## **FIRE RISK MANAGEMENT, INC**

# **Memo Report**

**Subject: Code Review; ICW Proposed Fire Alarm System Alterations at 1 City Center (1<sup>st</sup> Fl), Portland, ME**

**Partial Plan
First Floor**
(Scale as noted on Plan)

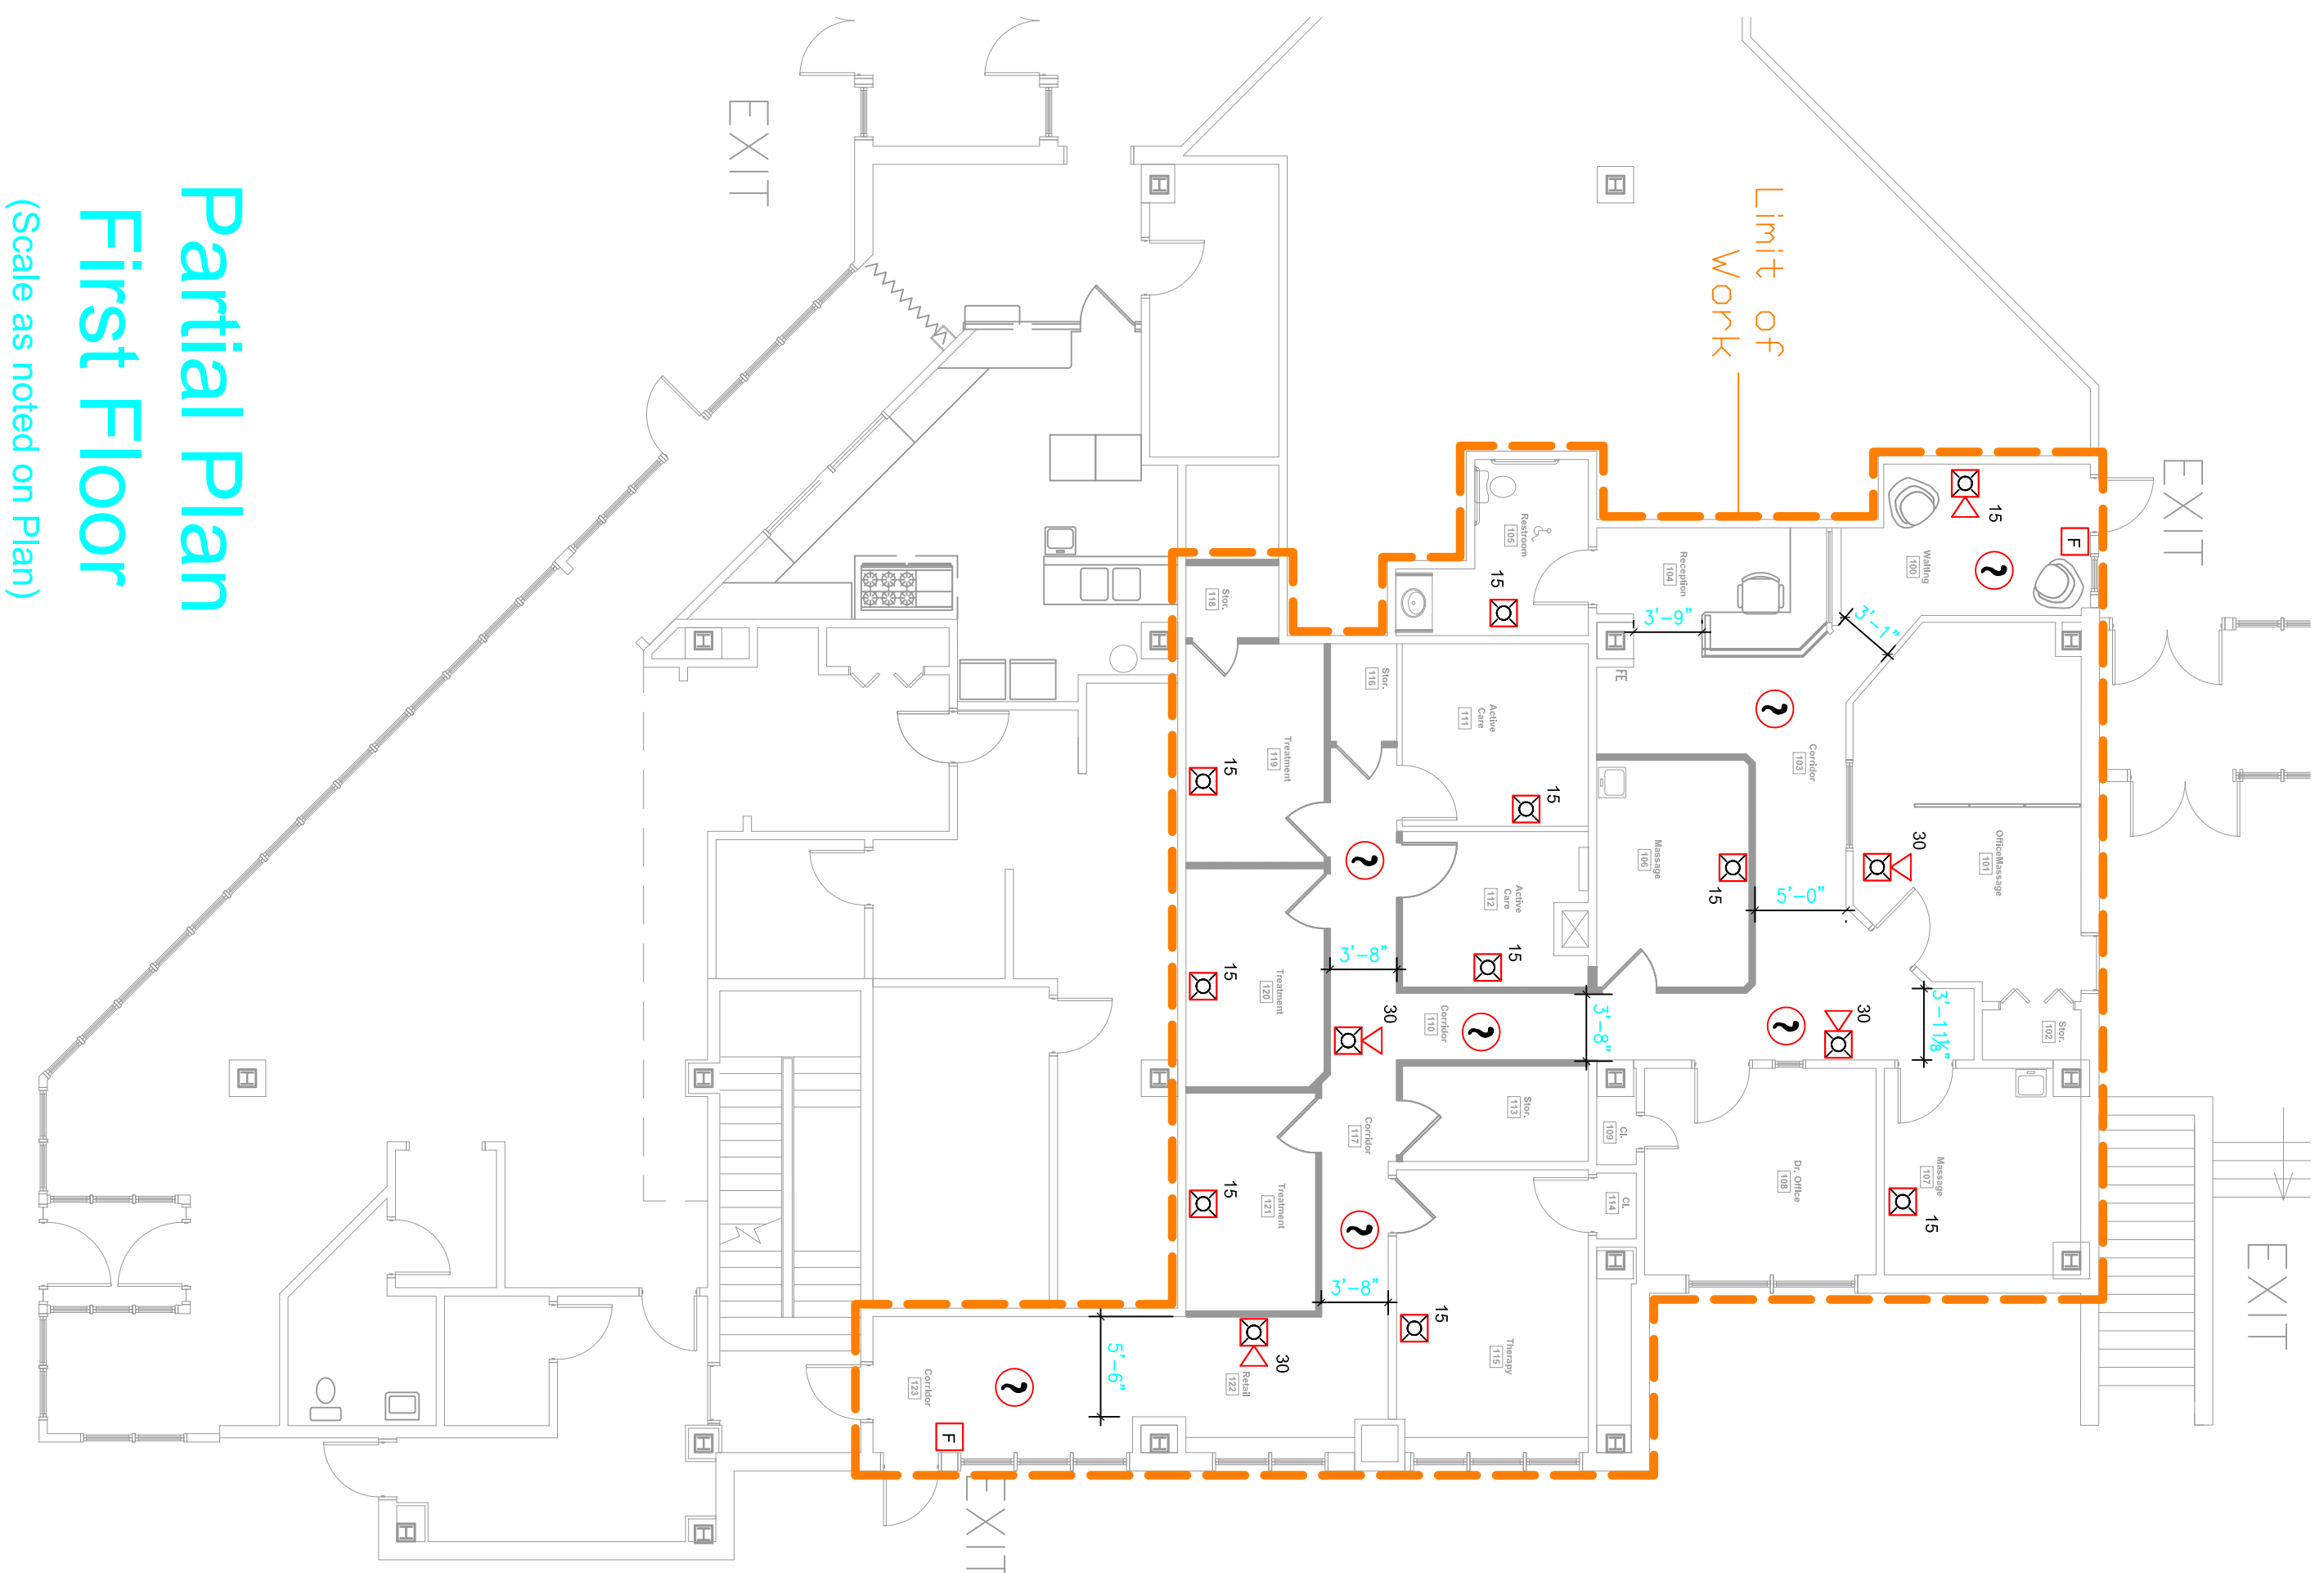
In general, the review indicates that the proposed modifications to the building’s fire alarm system will be code compliant. In fact, it appears that this proposed design will exceed the requirements of NFPA 72; as pertaining to the types and numbers of devices installed. Specifically, this design includes the installation of smoke detectors throughout all corridors. As outlined above, it is assumed that this building is fully protected with an automatic fire sprinkler system and it would be unnecessary to install smoke detection within these areas.

appears to be compliant with all code requirements, it is recommended that the need for smoke detection in the corridors be verified as needed/desired and that the operational matrix be updated to match the narrative. If you have any questions regarding what has been outlined above, please don't hesitate to contact me.
